M5 Junction 10 Improvements Scheme

**Applicants response to Interested Parties Deadline 9a
and Deadline 10 submissions**

Applicant Response to Interested Parties Deadline 9a and Deadline 10 submissions

Rule Number:	Rule 8 (k)
Planning Inspectorate Scheme Reference	TR010063
Application Document Reference	TR010063/APP/9.100
Author:	M5 Junction 10 Improvements Scheme Project Team

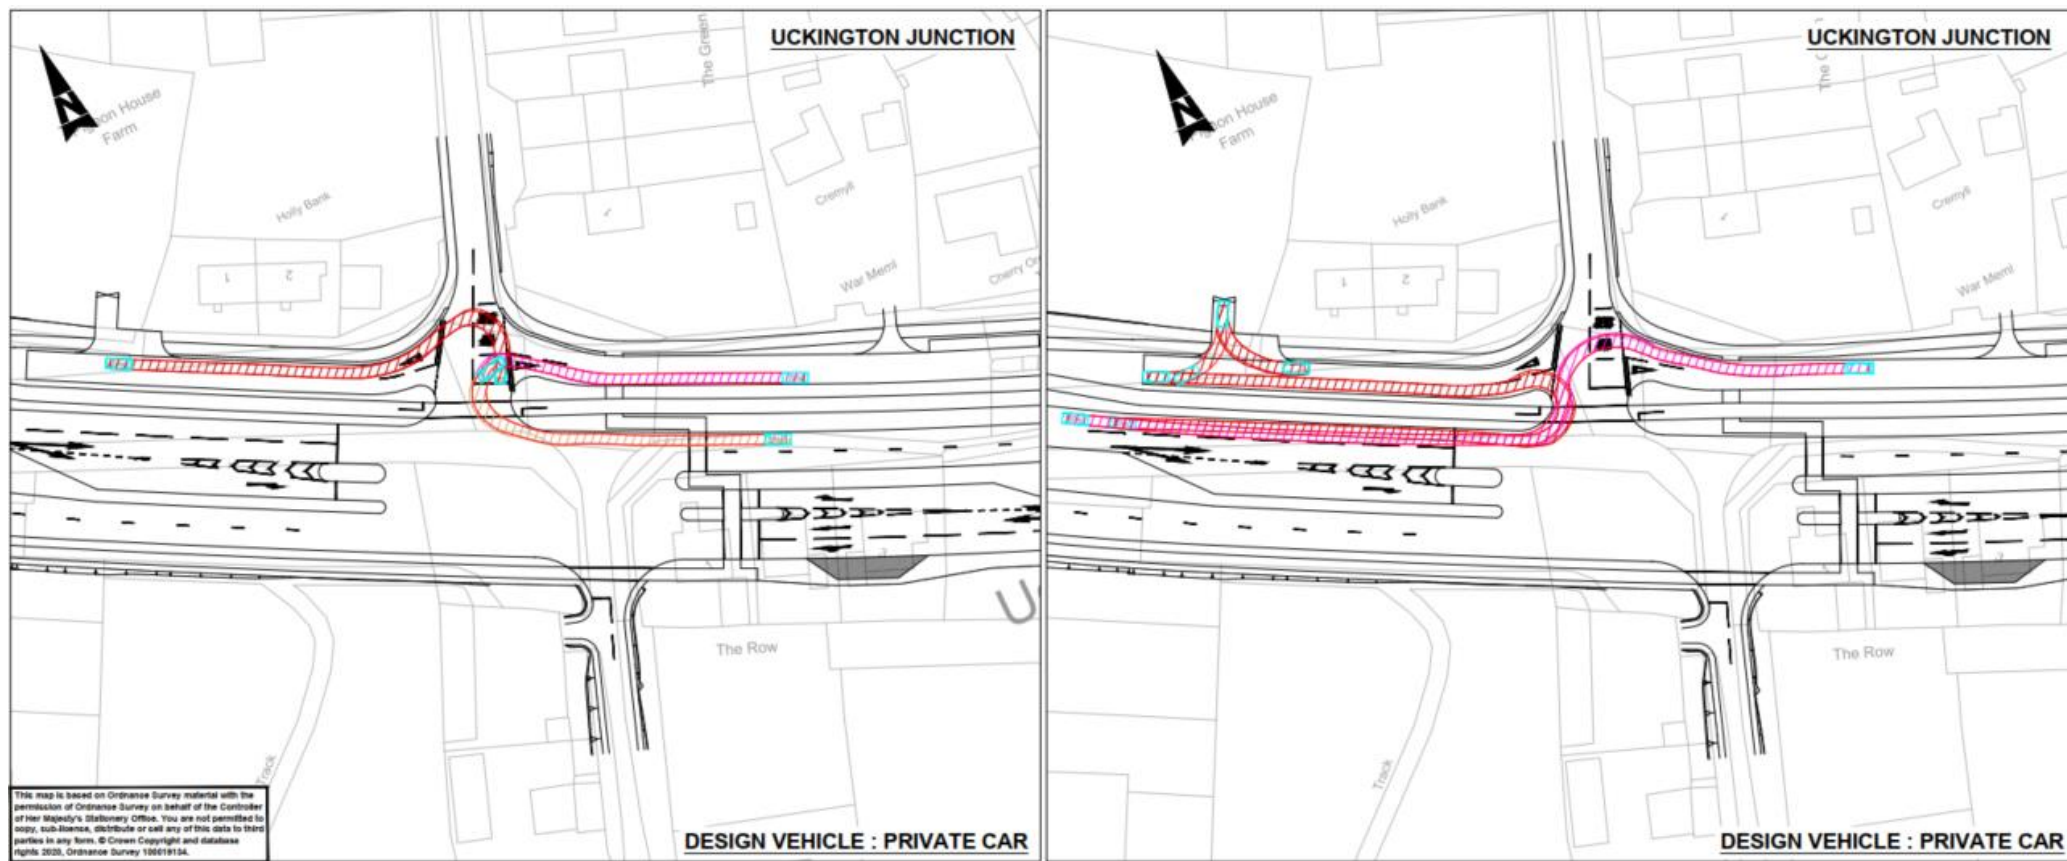
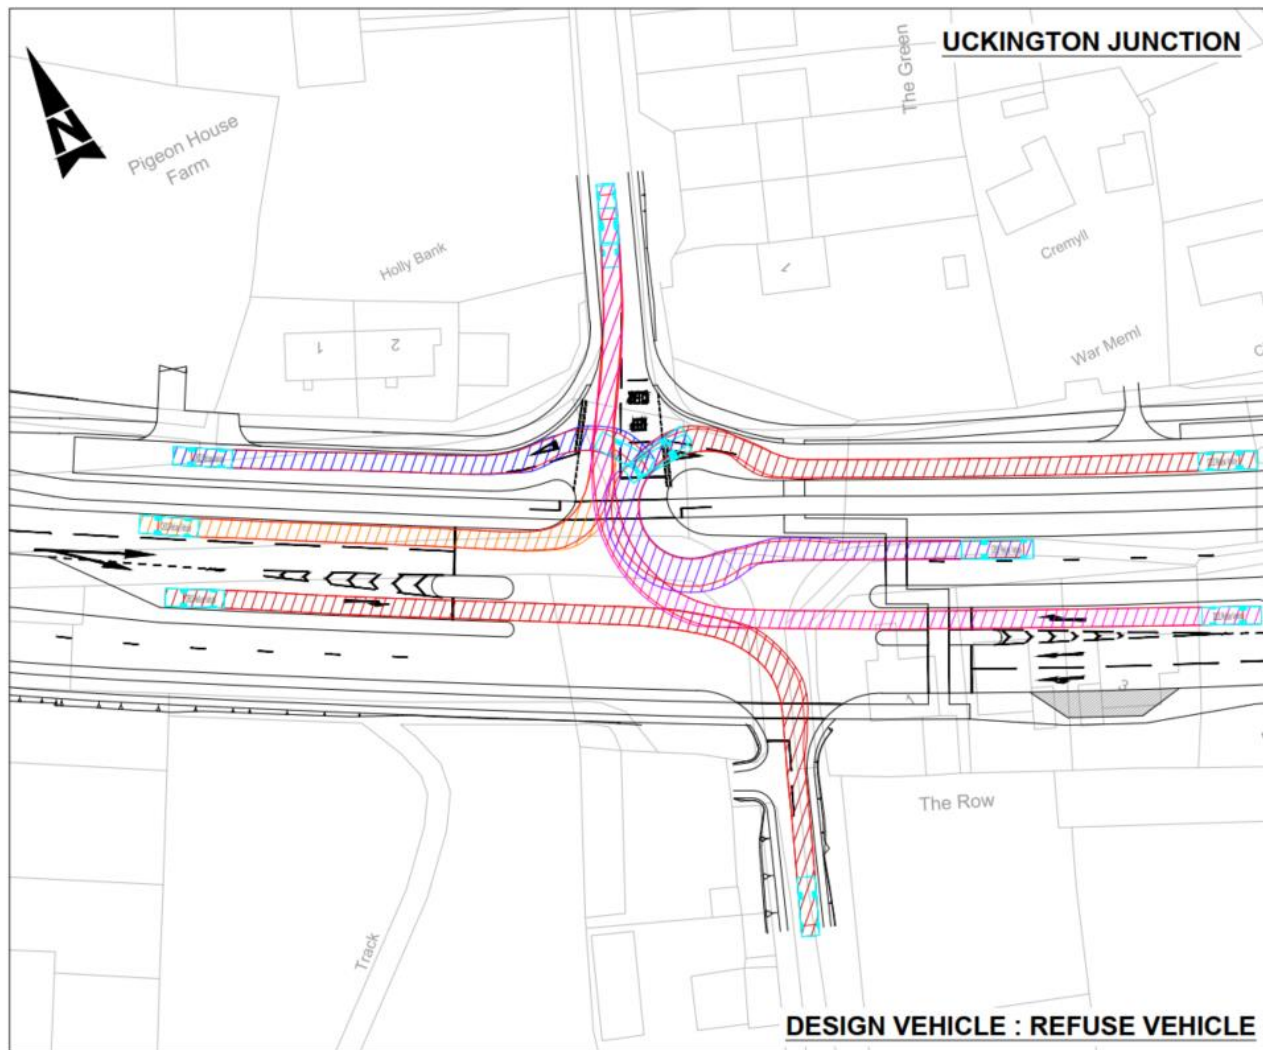
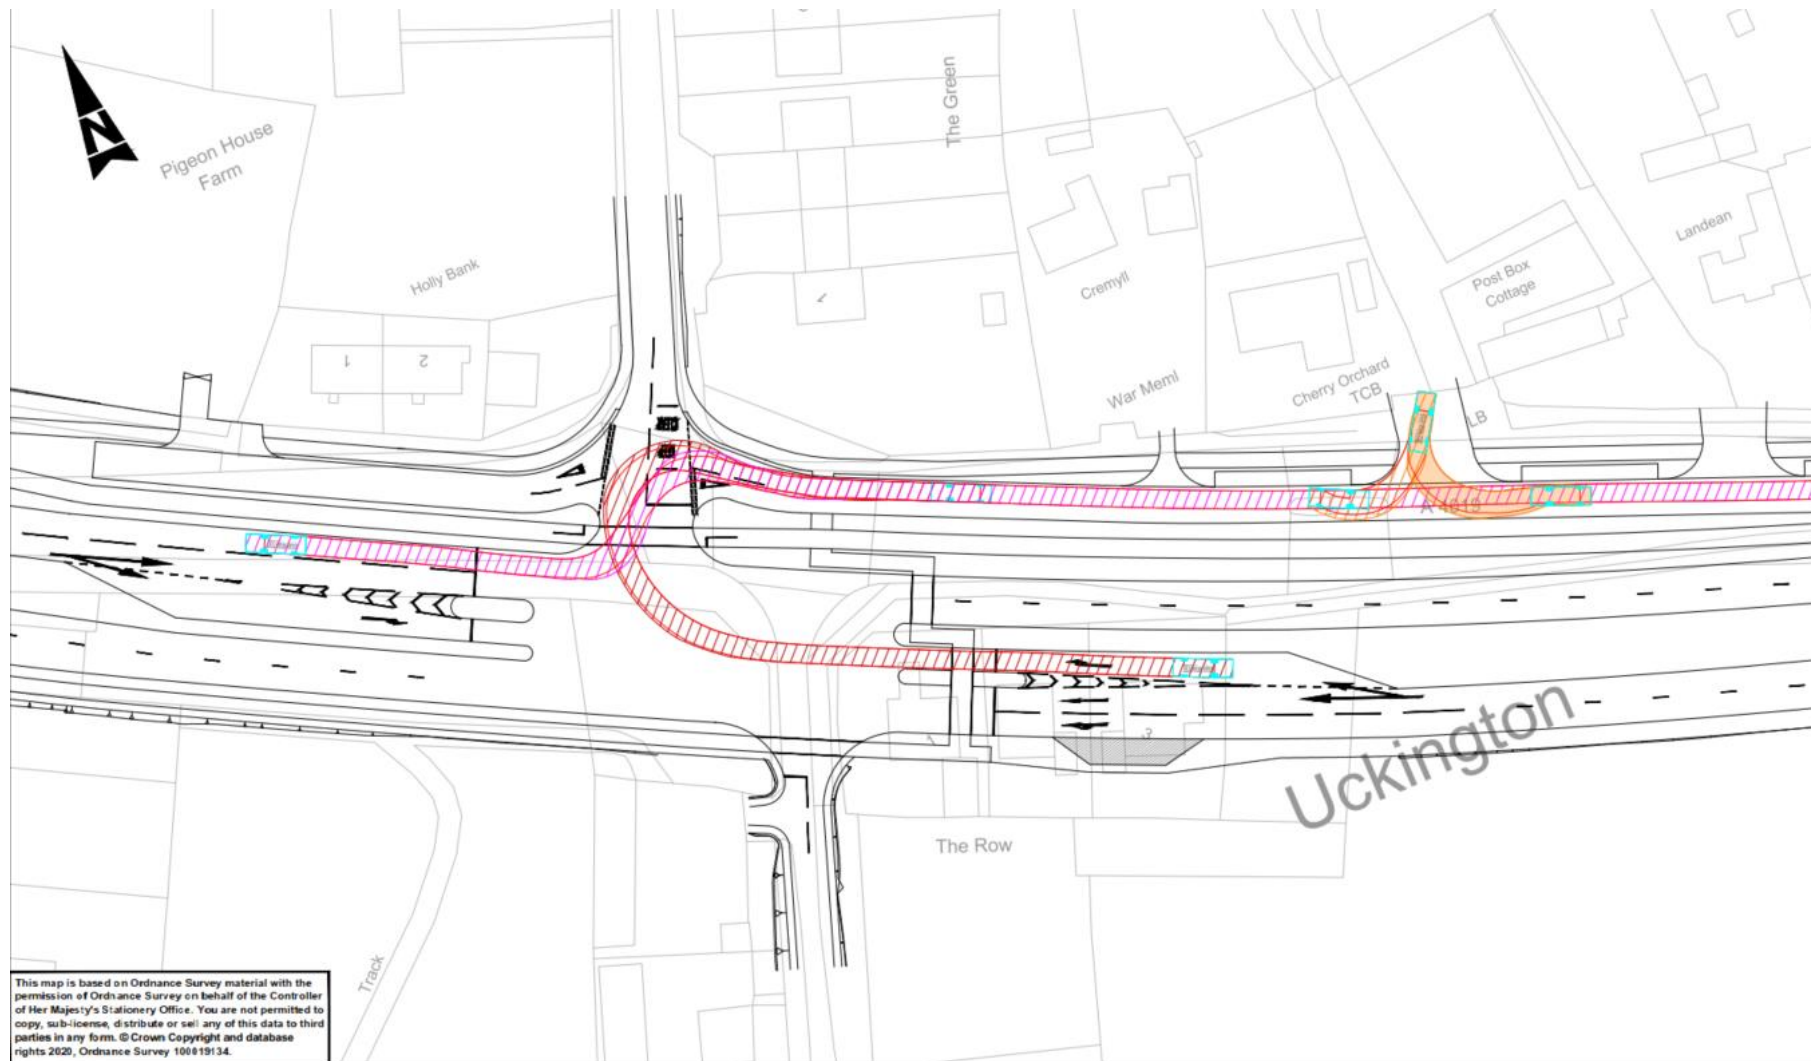
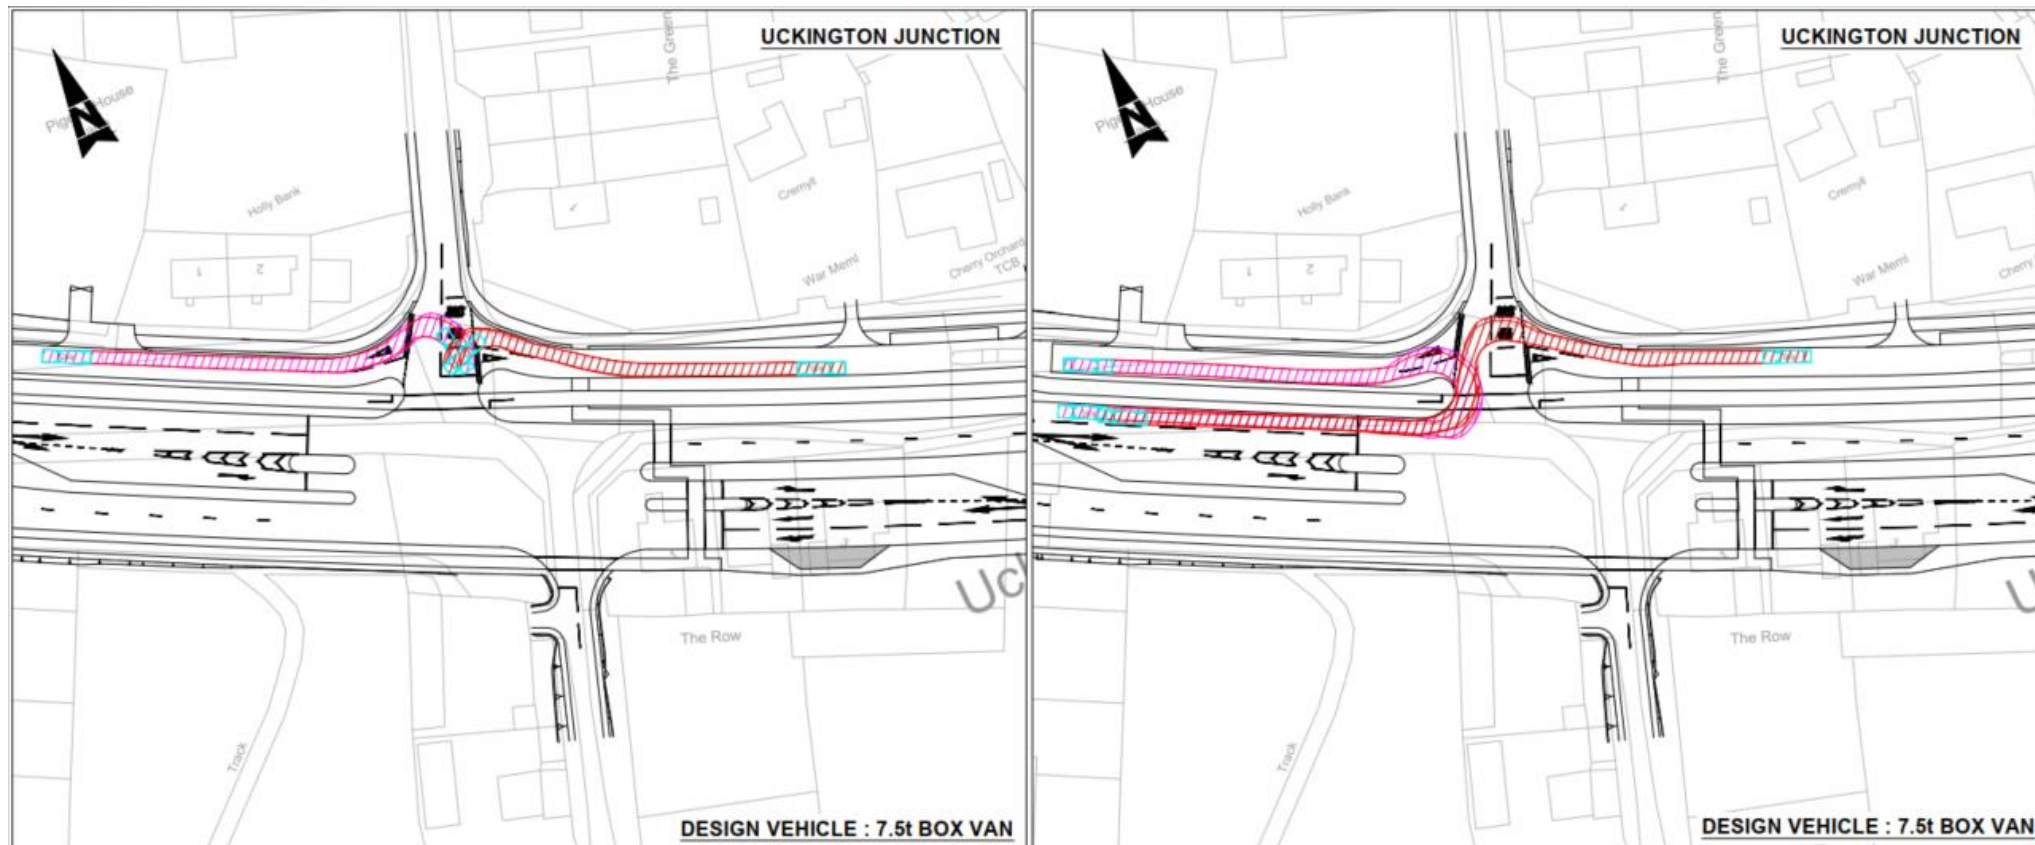
As it is, my existing agricultural access is going to become a major highway safety issue, as the size of machinery we use cannot be safely accommodated when crossing the road. The Applicant has tried to justify the agricultural access improvements, but as the swept path analysis drawings illustrate, the machinery illustrated is much smaller than we use and tractors with heir trailers cannot turn at right angles into stationary/moving traffic. Therefore the proposal simply does not work at a practical/safety level.

Ref	Issue	Applicant Response
1. Proposed shared farm access track		
	<p>The swept path analysis provided included agricultural machinery that is no longer made; current machinery such as trailers and combine harvesters are larger and it is important that we have confidence that they can not only navigate the access track bends, but also safely make the turn in to and out from my clients' land, when under heavy and high loads, without having to cross the adjoining land owned by the Applicant. One of the reasons for this is that my clients' must be able to keep the track level for the stability of bales of straw, which are at their most danger of toppling when a tight turn is being made over uneven ground. Updated drawings have been requested and chased but are yet to be received.</p>	<p>The Applicant has provided a range of plans to the Interested Party during examination which demonstrate the suitability of the access provided for the Scheme for agricultural vehicles. The specific make and model of the vehicle used in the analysis is not determinative to the validity of the assessment. The size, characteristics and manoeuvrability of the vehicles is the key and, in the Applicant's opinion, the performance of the vehicles in the swept path analysis is representative of the large agricultural vehicles that has been referenced by the Interested Party. For the avoidance of doubt, the attached drawings were issued to Mr Bower on the 29 October 2024 and demonstrates the suitability of the private means of access up to the field gate. Previous drawings were issued to the Interested Party on the 21 June 2024. It is the Applicant's view that the drawings issued on the 29 October addressed these concerns. The Applicant has confirmed the private means of access will be constructed to an appropriate standard which incorporates best practice methods of construction and will be formed of compacted stone to ensure a level and stable surface. The Applicant maintains that the design of the access is safe and suitable for the use of the land.</p>
